From: [REDACTED]
To: [Metrowest1](#)
Subject: Hearing 3, Day 1 - Written Comments/Questions regarding Lodway Farm Construction Compound - W E Ovel
Date: 11 January 2021 19:04:21

Please find below the questions and comments with respect to the Lodway Farm Construction Compound that I briefly introduced today at Issue Specific Hearing 2, Day 1, Agenda item 5, Construction Practices.

Ref: DCO, Section 5.4, Construction Strategy

Drawn
COMPOUNDS, HAUL ROADS AND ACCESS TO WORKS PLAN SHEET 5

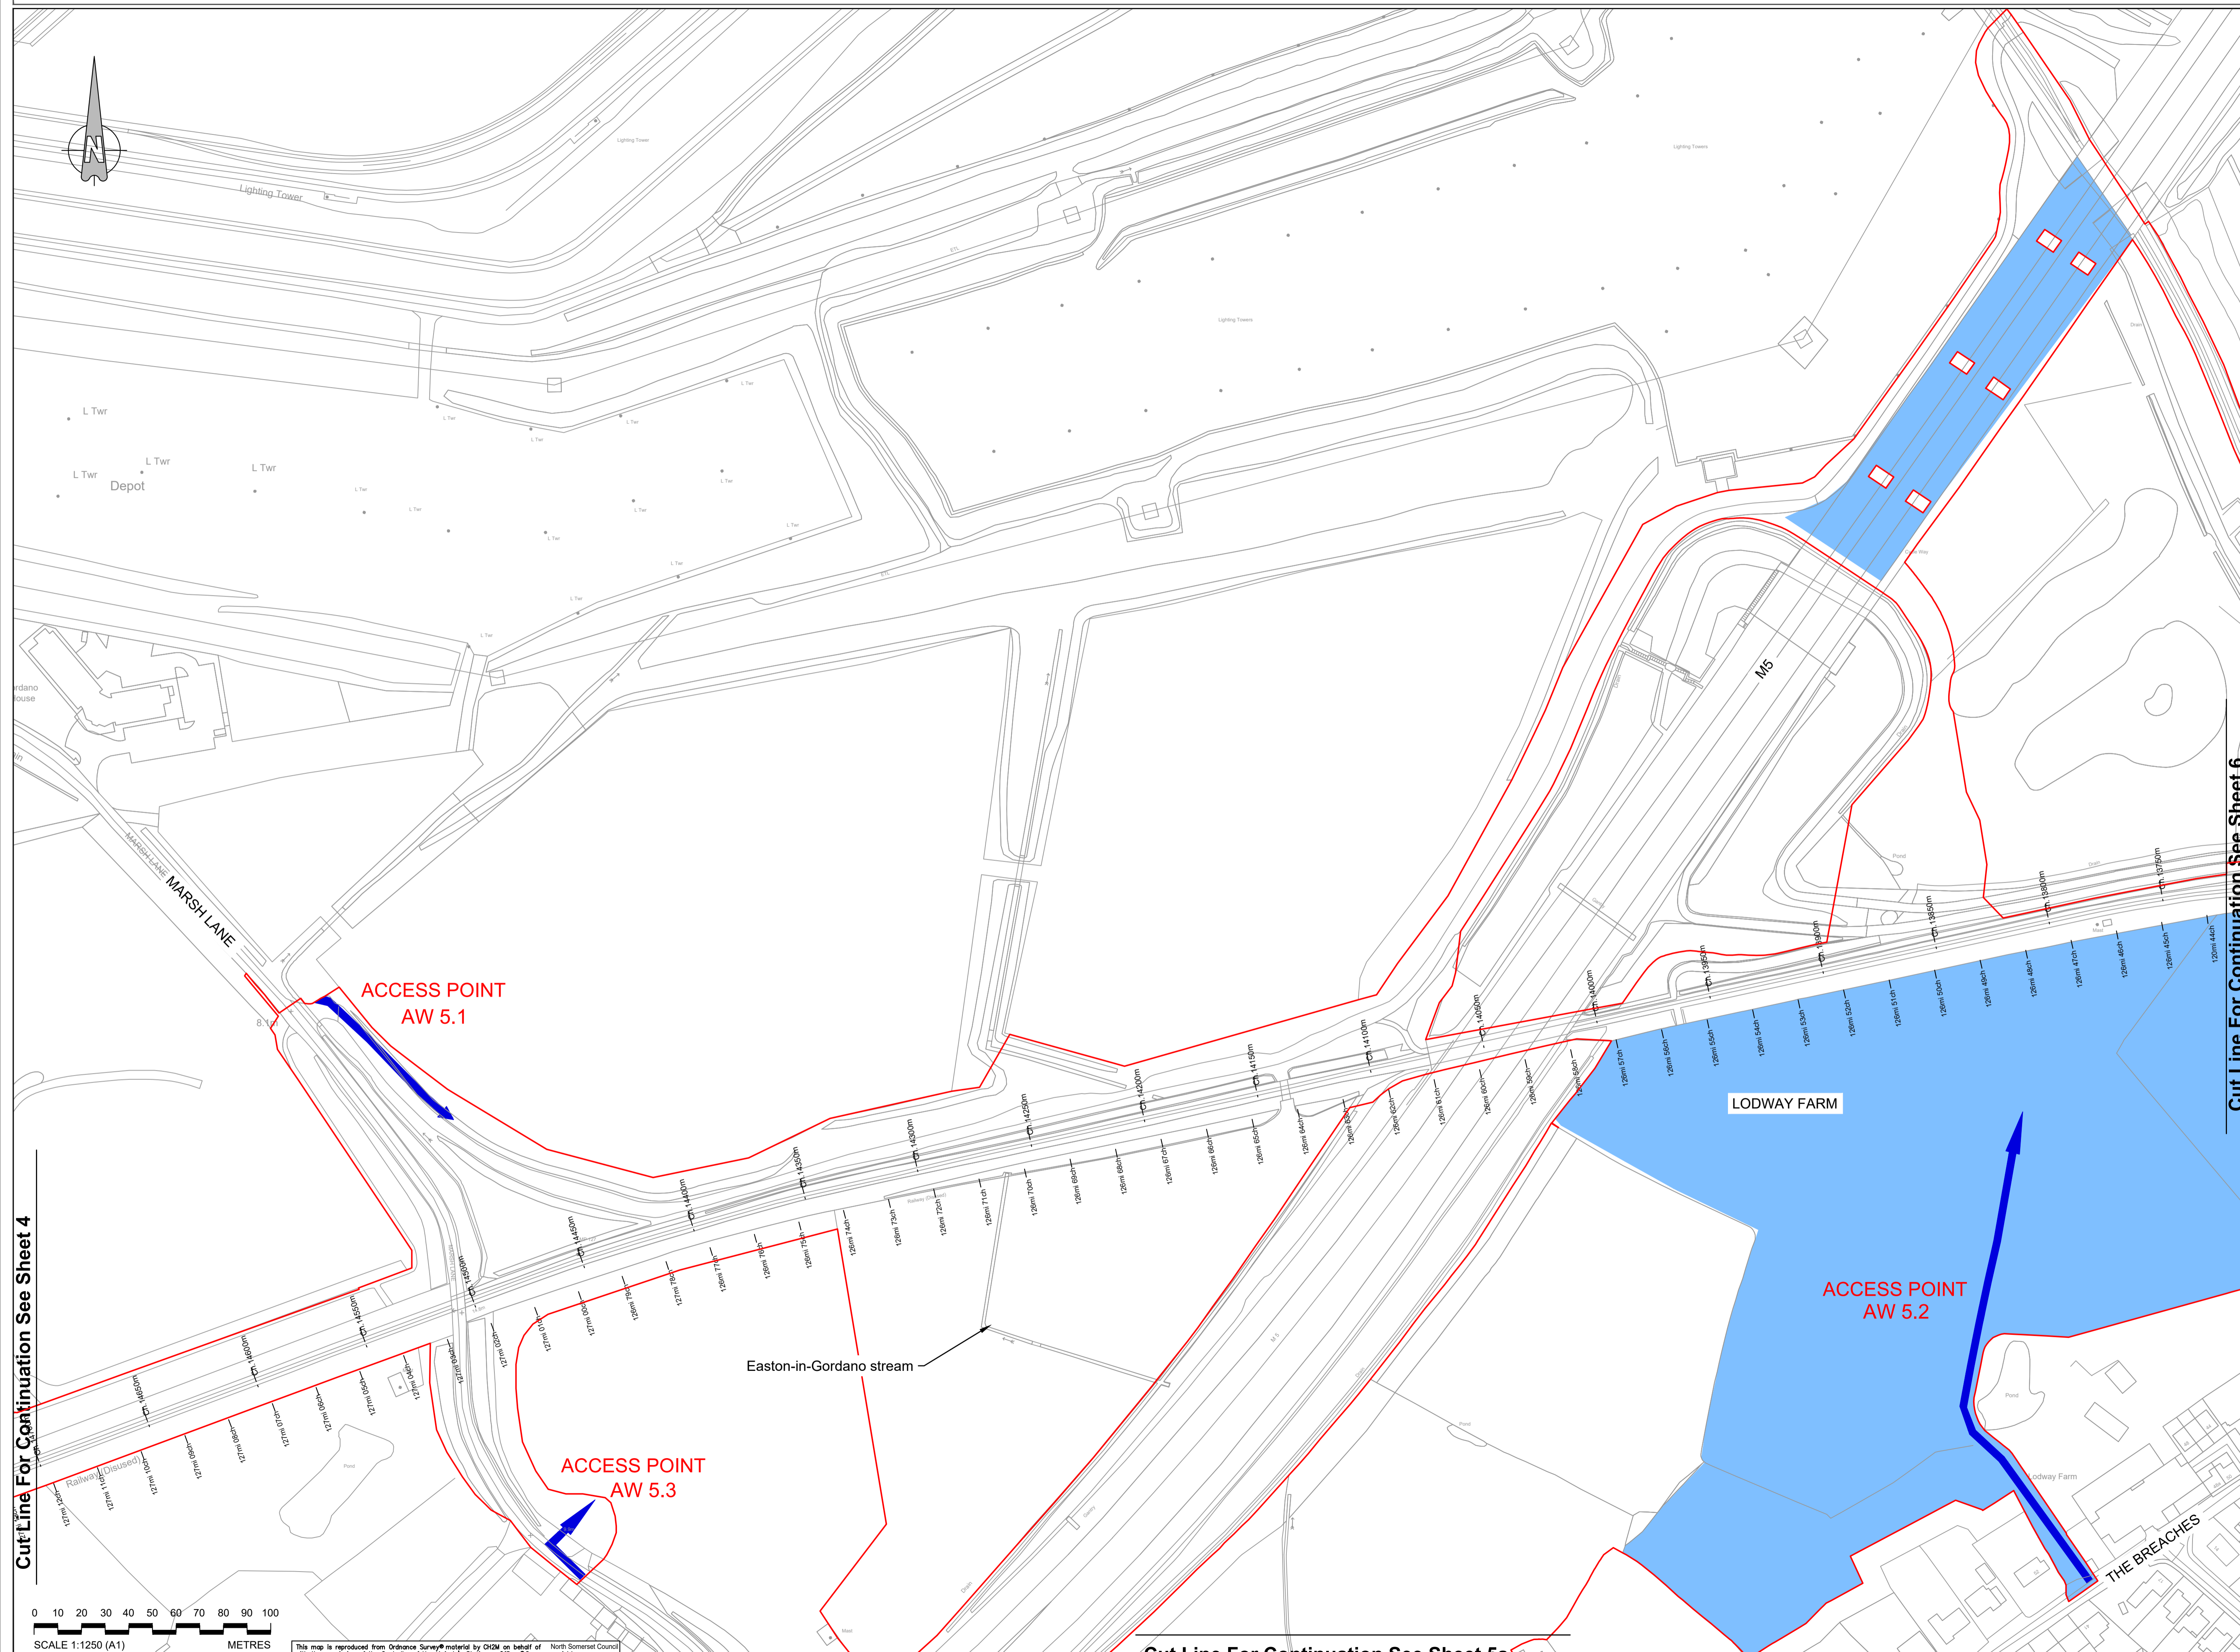
c. Could the area of land to the north of the M5 overbridge and under the M5 road bridge be used more intensively for construction activity purposes in order to off-load the Lodway Farm compound?

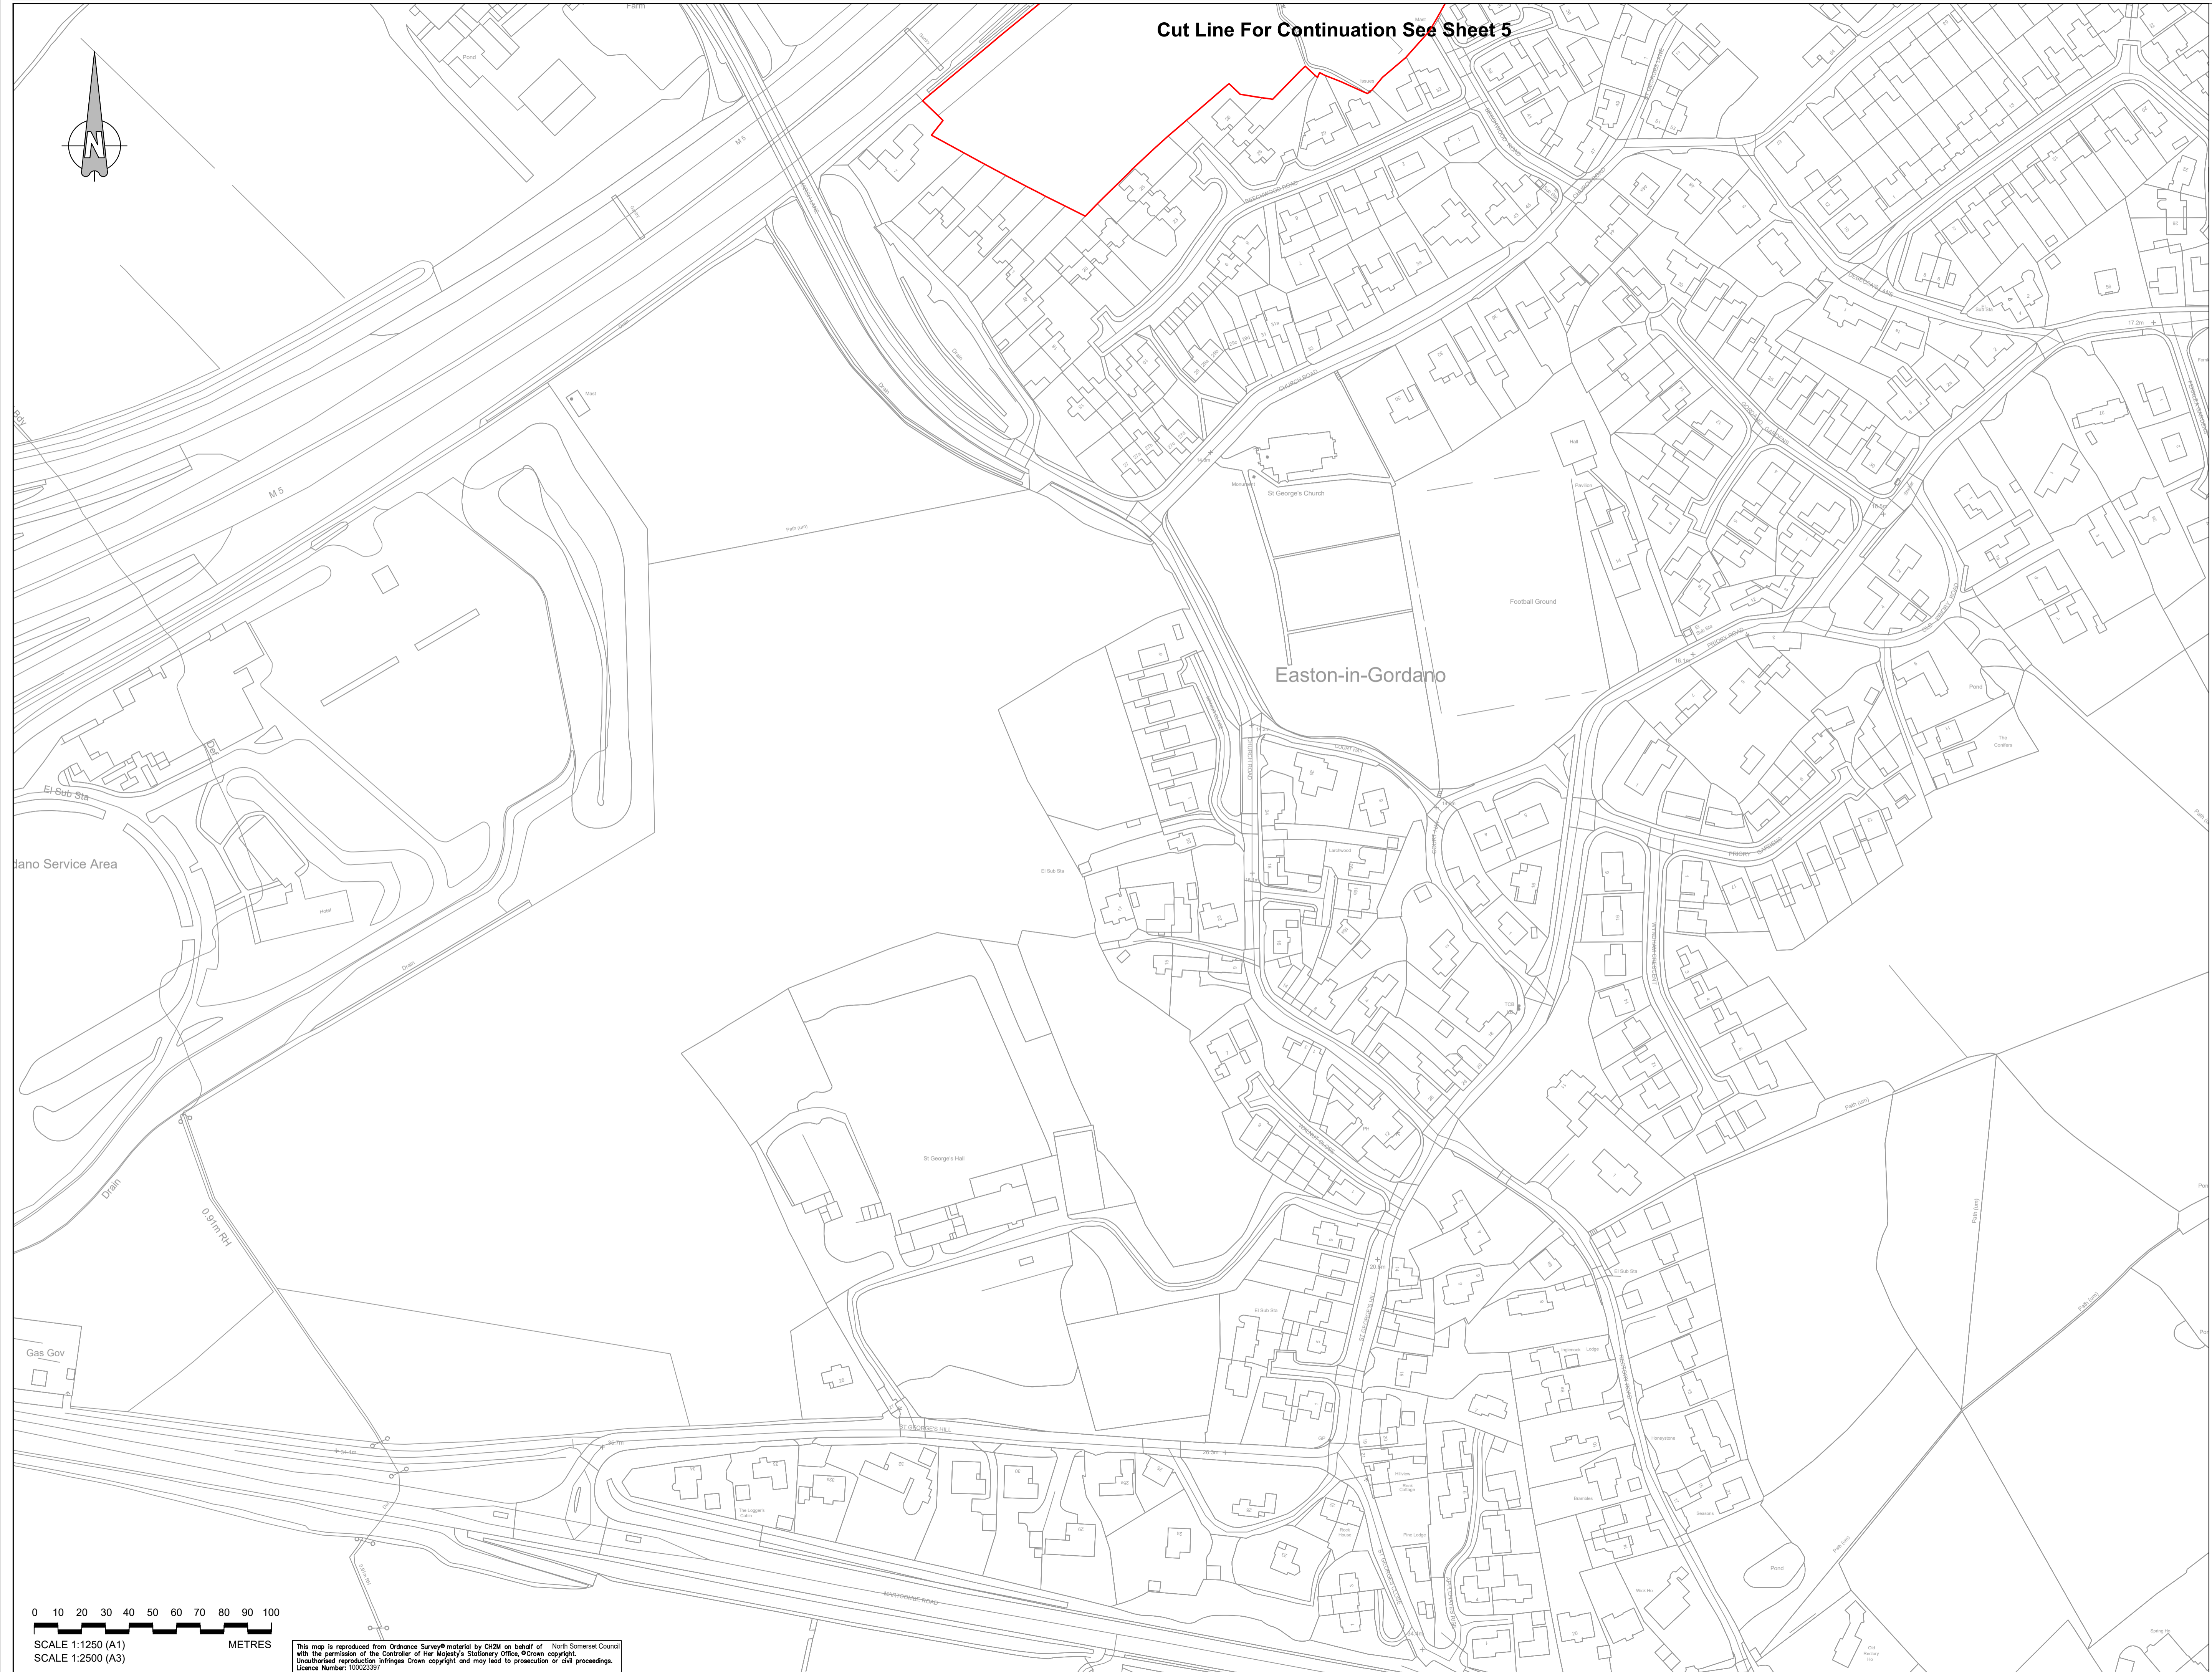
a. Why is the Lodway compound so large? (8.9 hectares by my calculation). This encompasses most of the Lodway Farm greenfield space. The Lodway Compound should be as small as possible to minimise its environmental impact.

b. Could it be smaller? (Ref, page 33, states that a minimum storage area of 40 metres by 135 metres would be required for waste material storage at the Portbury Dock collard. Storage of waste material seems to be potentially the biggest driver in terms of the surface area required for the compound. By my calculation this is about 0.5 hectare, which would equate to just 6% of the proposed Lodway Compound area. If there are other activities that require very large areas then I would appreciate knowing what they are.

a. The waste material is acknowledged to be probably contaminated (Ref, page 33). At Ref, page 34, several possibilities for storage and disposal of the potentially contaminated waste are put forward but a decision on which method will be used or even preferred is deferred until a later date. The Lodway Compound lies to the south and west of, and in close proximity to, the Pill/Easton-in-Gordano residential areas. The prevailing wind direction is south-westerly. There is a credible risk that if the waste is stored at Lodway Farm, contaminated dust could blow it over those residential areas with consequent health hazards.

(1) Storage at Lodway Farm should be the option of last resort

(2) If there is no alternative, the waste should be stored as far away from housing as physically possibly

(3) Waste should be removed from the site within an agreed, short, time period (I deliberately avoid saying as soon as possible because that could mean years)

3. Removal of Waste Material. Ref page 36, Option 2d - Temporary Siding at Lodway - discusses the possibility of a temporary junction or turnout adjacent to the Lodway Compound. From the point of view of minimising the number of HGV movements, this would clearly be by far the best option. The number of movements is estimated at Ref,

page 38, as amounting to 1200 to 1800 journeys by 20 tonne tipper trucks. The uncertainty surrounding this option should be resolved and it should become the preferred option.

4. HGV Access to Lodway Farm via The Breaches. It was explained by the applicant today that the haul road would be too narrow to accommodate simultaneously both HGVs and other construction traffic, hence there was a need for worker's vehicles to access the compound via an alternative route. The only option presented for this access is via the Lodway Farm access off The Breaches. This is as maybe, but it does not explain why there also has to be access for HGVs via the Breaches. As stated by the other two Pill residents who spoke this afternoon, this route is totally unsuitable for HGV use. Is there an expectation that the haul road will become unavailable, thus necessitating an alternative route? If so, any large scale diversion of HGVs to this route would be intolerable for residents, not only because of the impracticability of using the Breaches, but also the extensive use of the narrow village roads that would be entailed, whichever direction they approached from. HGV access via the Breaches should be excluded from Construction and Transport Plans, with no exceptions allowed.

5. Construction Compound Noise. The proposed boundaries for the Construction Compound about the adjacent residential property boundaries. Given the proposed working hours and the likely nature of the activity involving heavy machinery, it is guaranteed that it will generate a considerable noise nuisance. This is exacerbated by the prevailing wind direction. Whilst the need for a construction compound in this location is reluctantly conceded, it should be as small in area as possible to enable the required activities to be conducted and with the noisiest activity taking place as far from residential areas as possible. This should be done to make the noise nuisance situation as tolerable as possible for the neighbouring residents who will have to bear it for up to years once construction starts. This same consideration of small size, as far away as possible, also applies to minimise the effect of light and air pollution on the local population.

6. Wildlife. Although today's agenda item related to the construction practices, I would like to add, the the sake of completeness regarding this submission about Lodway Farm, that there are also significant concerns within the local community about the impact of the compound and associated activities on the wildlife of the area. Of particular concern is the very large, nationally significant toad population that is resident on the farm and migrates annually across the line of the railway. Clearly, there is going to be a massive, long term change to the circumstances of this population but, once again, the impact should be minimised as far as possible, by keeping the size of the compound as small as possible
